**KIRKLEES METROPOLITAN COUNCIL
INVESTMENT & REGENERATION SERVICE**

**DELEGATED DECISION FOR DISCHARGE OF CONDITION A.4 -
NOTIFICATION OF A PROPOSED ENLARGEMENT TO DWELLINGHOUSE**

Reference no.	2025/HH/91474/E
Site Address	45, Leeds Old Road, Heckmondwike, WF16 9AA
Description	The proposal is for erection of single storey rear extension. The extension projects 6m beyond the rear wall of the original dwellinghouse. The maximum height of the extension is 2.5m, the height of the eaves of the extension is 2.5m
Recommending Officer	Molly Storer

DRAWING TITLE  
Proposed Layout

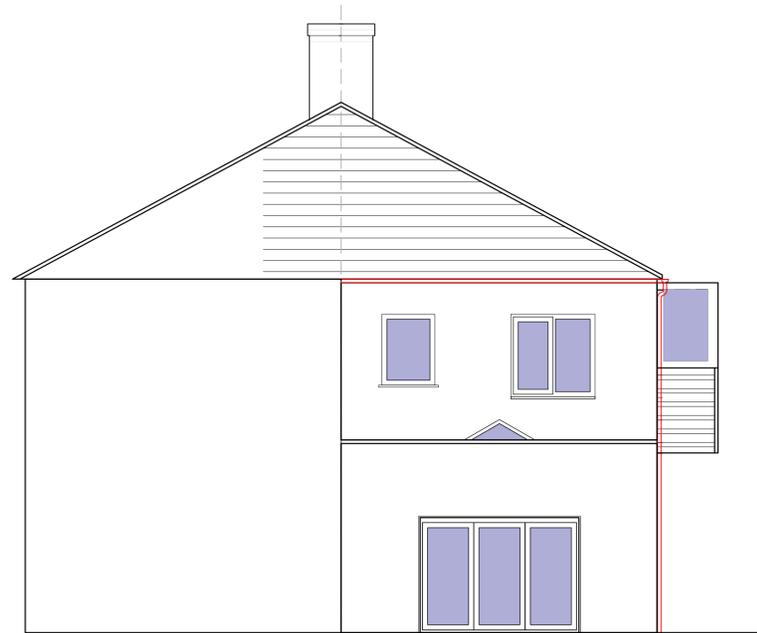
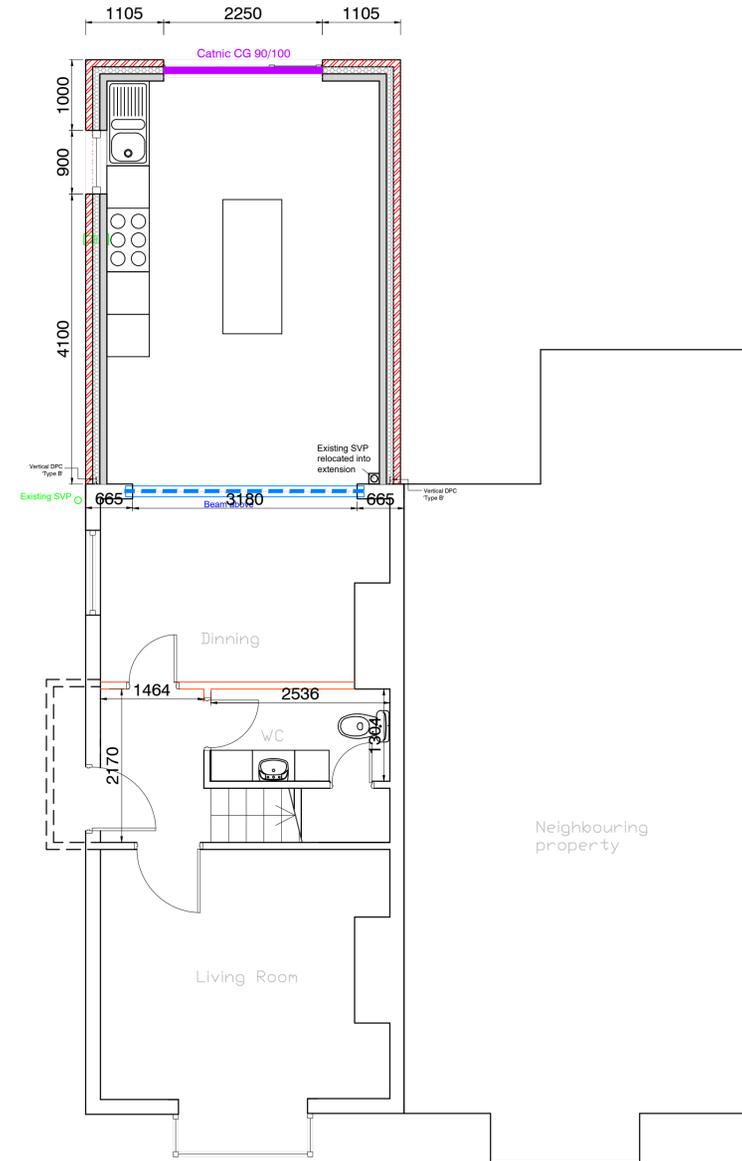
The proposed extension projects from the rear of the original dwellinghouse by 6 metres along part of the rear elevation and 4.3 metres beyond an existing part rearward projection which is proposed to be demolished. The Council's historical imagery dated 1922 does not show the dwellinghouse to have been built. However, imagery dated 1933, 1955, 1956, 1968 & 1968 consistently indicate the existing rearward projection was original to the dwellinghouse.

Having regard to the Government's householder guide to permitted development rights (2019) and sub-paragraph A.1(j), Class A, Part 1 of Schedule 2 of the Town and Country Planning (General Permitted Development) (England) Order 2015 (as amended) development is not permitted under Class A where the proposed extension extends beyond a side elevation of the original dwellinghouse and has a width greater than half the width of the original dwellinghouse. In this case the submitted plans indicate the proposed extension extends along the whole rear elevation of the property and is therefore contrary to paragraph (j) of Class A and as such cannot benefit from a permitted development.

The proposed enlargement does not benefit from a general planning permission under Article 3(1) and Class A, Part 1 of Schedule 2 of the Town and Country Planning (General Permitted Development) (England) Order 2015 as the rear projection extends beyond a wall forming a side wall of the original dwellinghouse and has a width greater than half the width of the original dwellinghouse contrary to sub-paragraph A.1(j) of Class A.
